CITY OF ALBUQUERQUE

August 10, 2022

Re: Duplex for Ahmet Tiryaki
12016 Copper Ave NE
Traffic Circulation Layout
Architect's Stamp 07-07-2022 (K22-D065)

DRAWING TITLE: **TRAFFIC CIRCULATION LAYOUT**

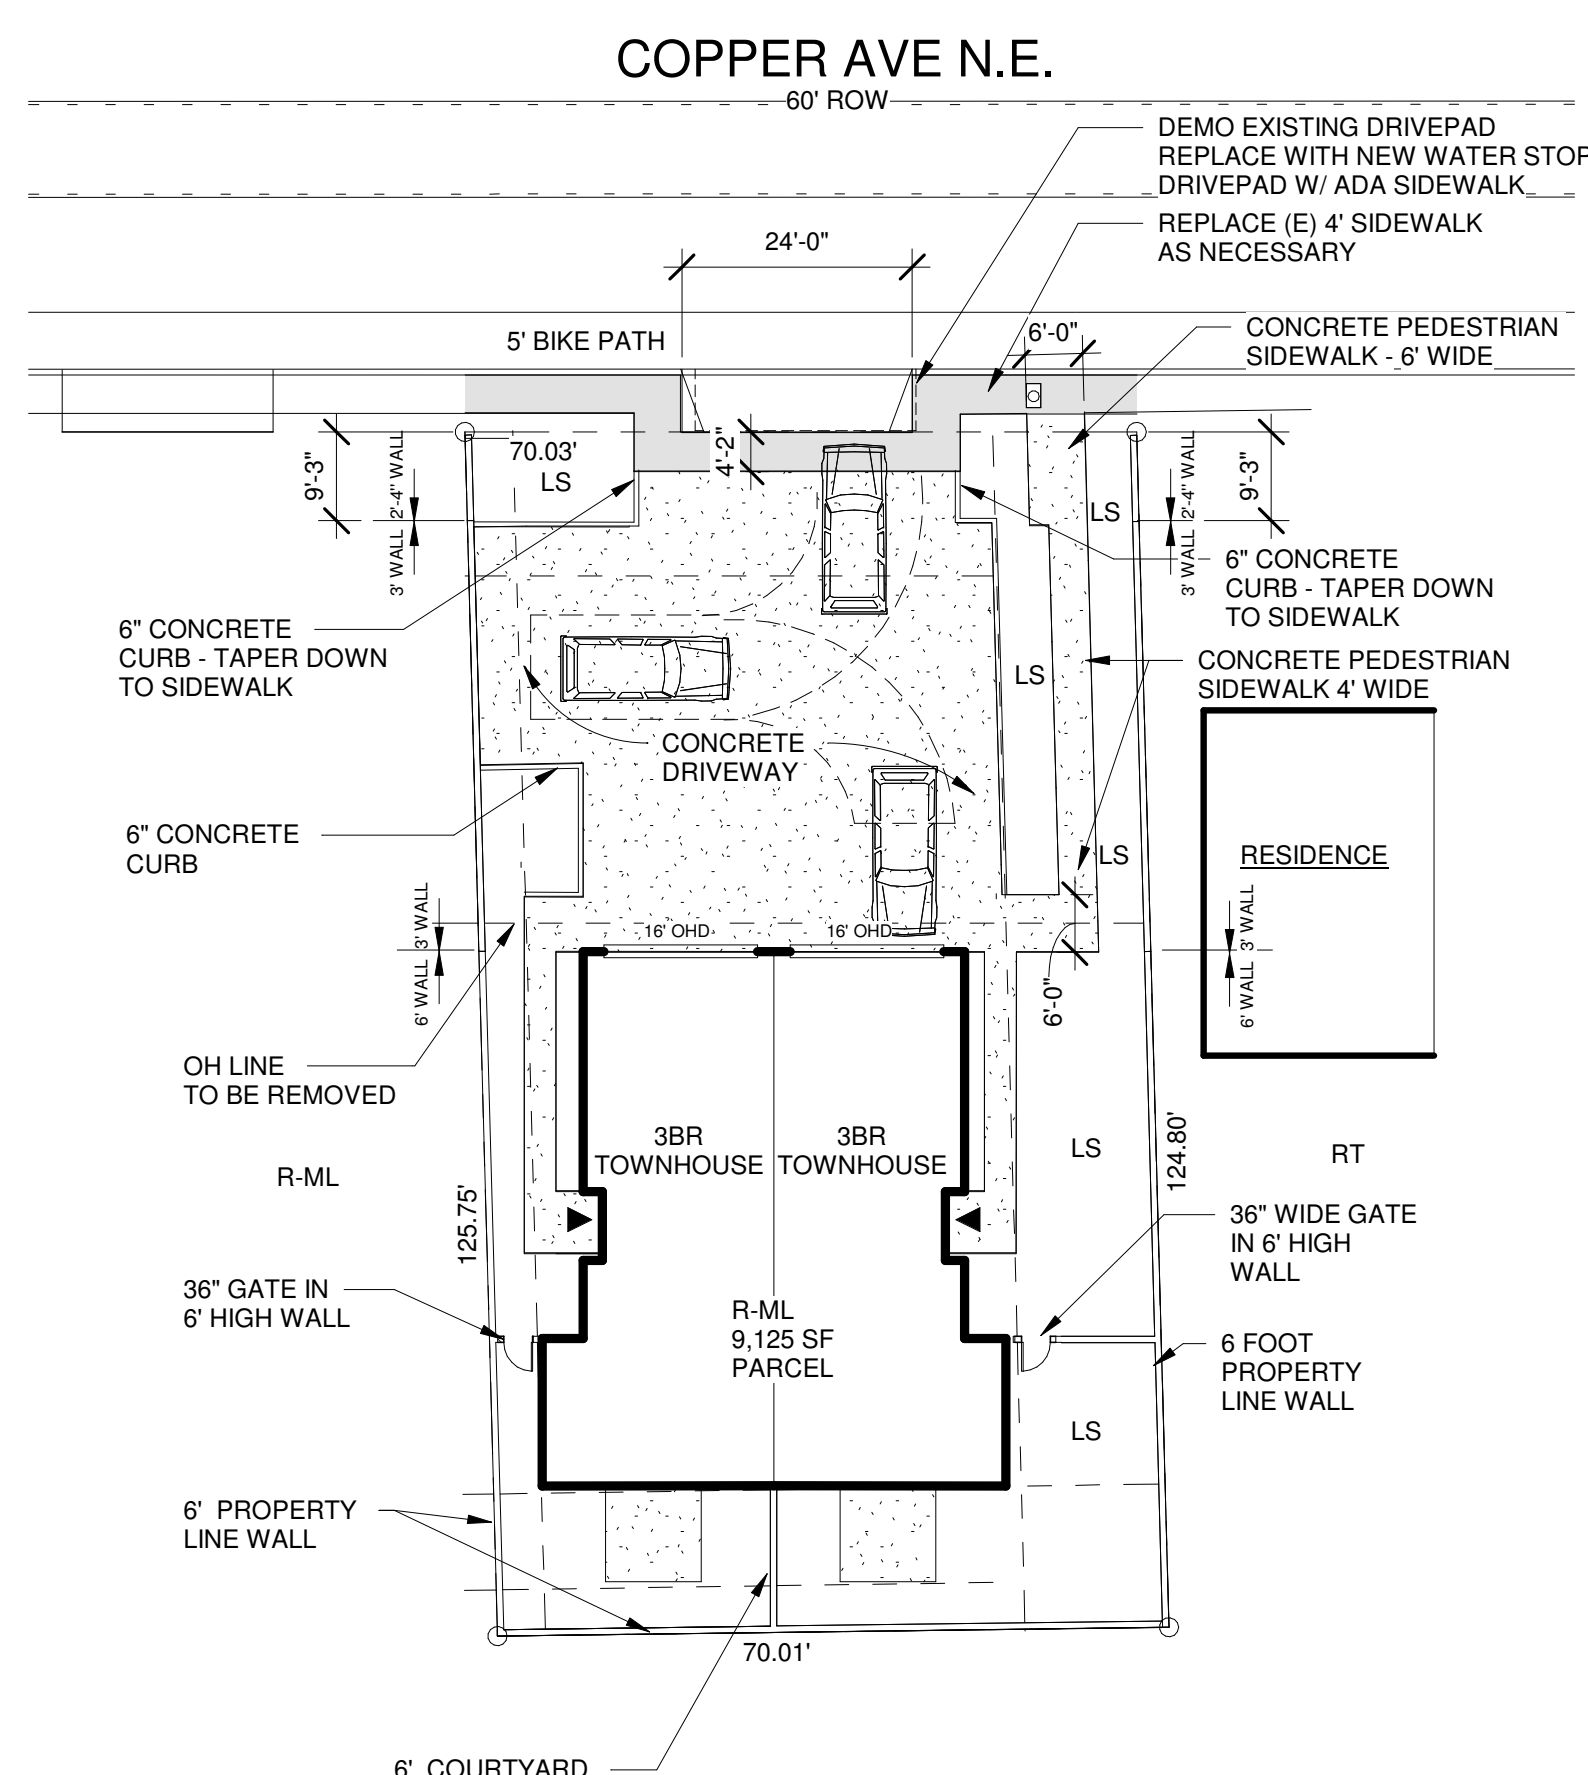
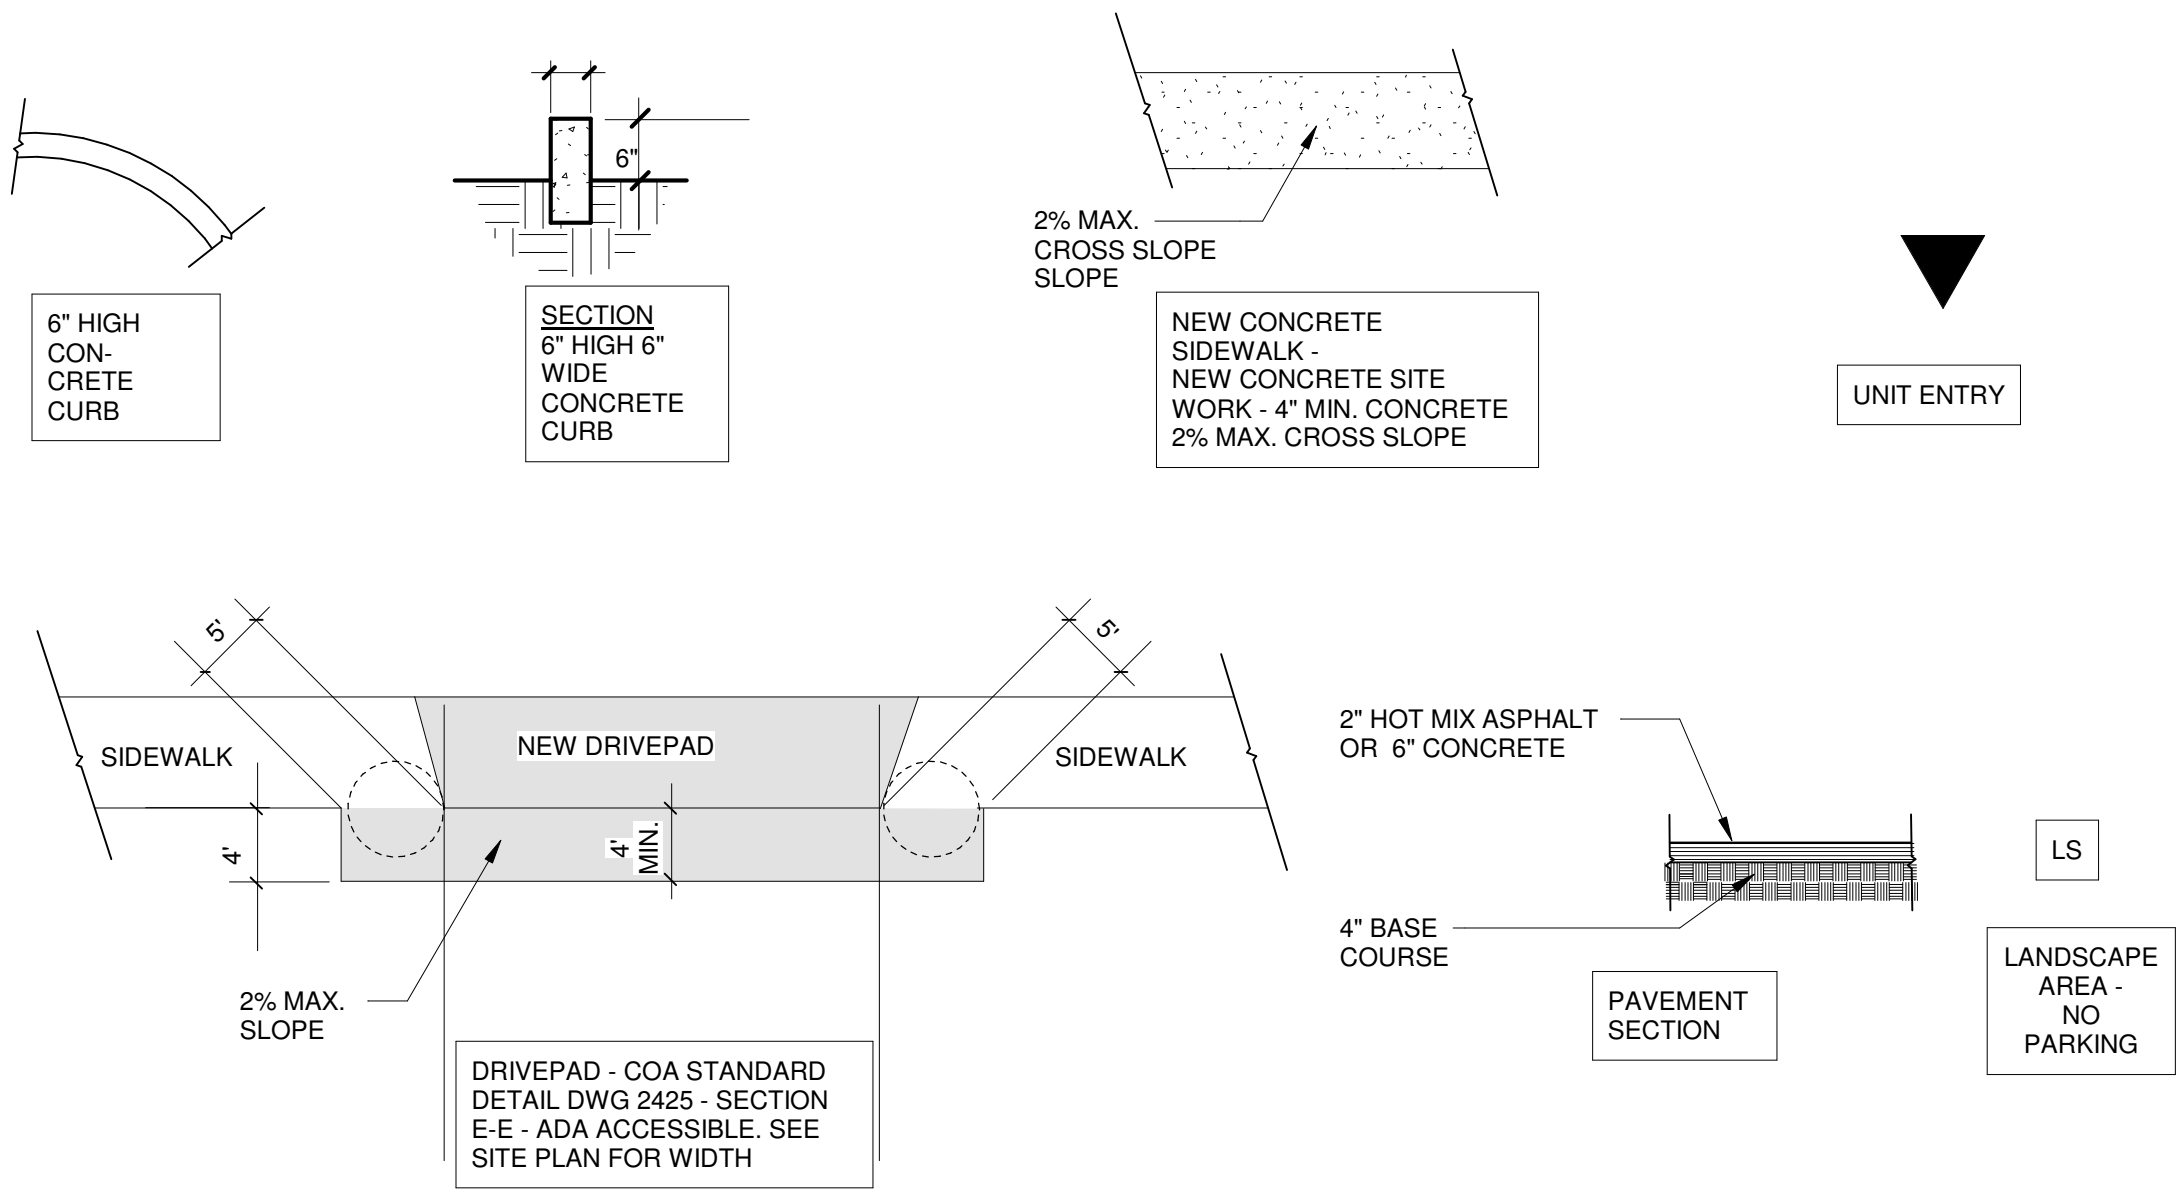
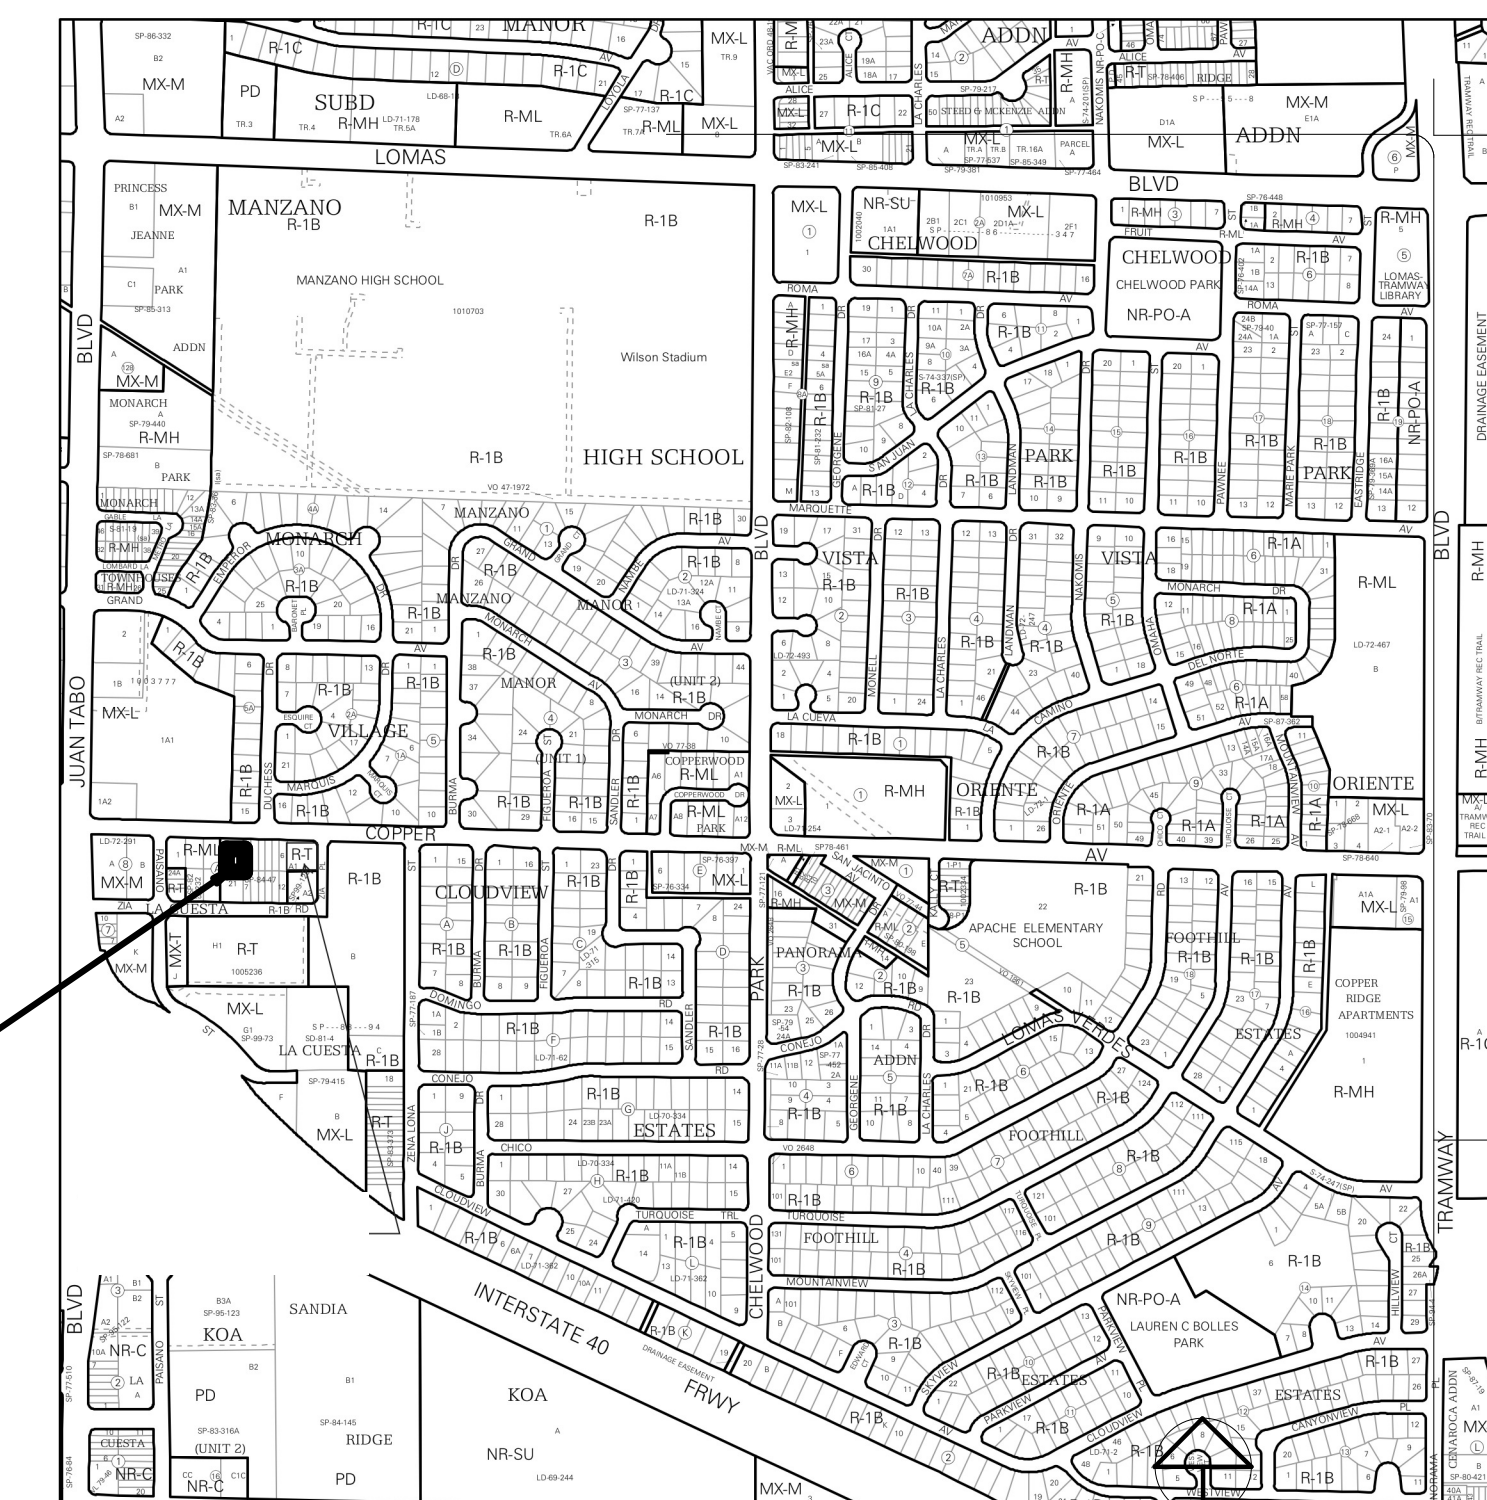
1. Listed are the number of parking spaces required by the IDO as well as the proposed number of parking spaces including bicycle and motorcycle parking.
Coordinate/discuss with Zoning.
2. **Copper Frontage:**
 - The new/proposed driveway will need to be a curb return design since Copper Ave is classified as a Collector roadway (Per DPM). Review COA std dwg 2426 for design and not the 2425 shown on plans.
 - Please adjust sidewalk connection onto property since the new driveway might conflict with ADA accessibility.
3. You will need a share access agreement for 6 ft pathway onto adjacent property/residence on the eastside of townhouse.
4. Please list the width and length for all proposed parking spaces. Some dimensions are not shown.
5. **The minimum parking stall dimensions are:**

6. All sidewalks along streets should be the appropriate widen per DPM requirements on a Collector roadway. Please verify the existing width meets the minimum requirement.
7. Provide a copy of refuse approval (**IF APPLICABLE**).
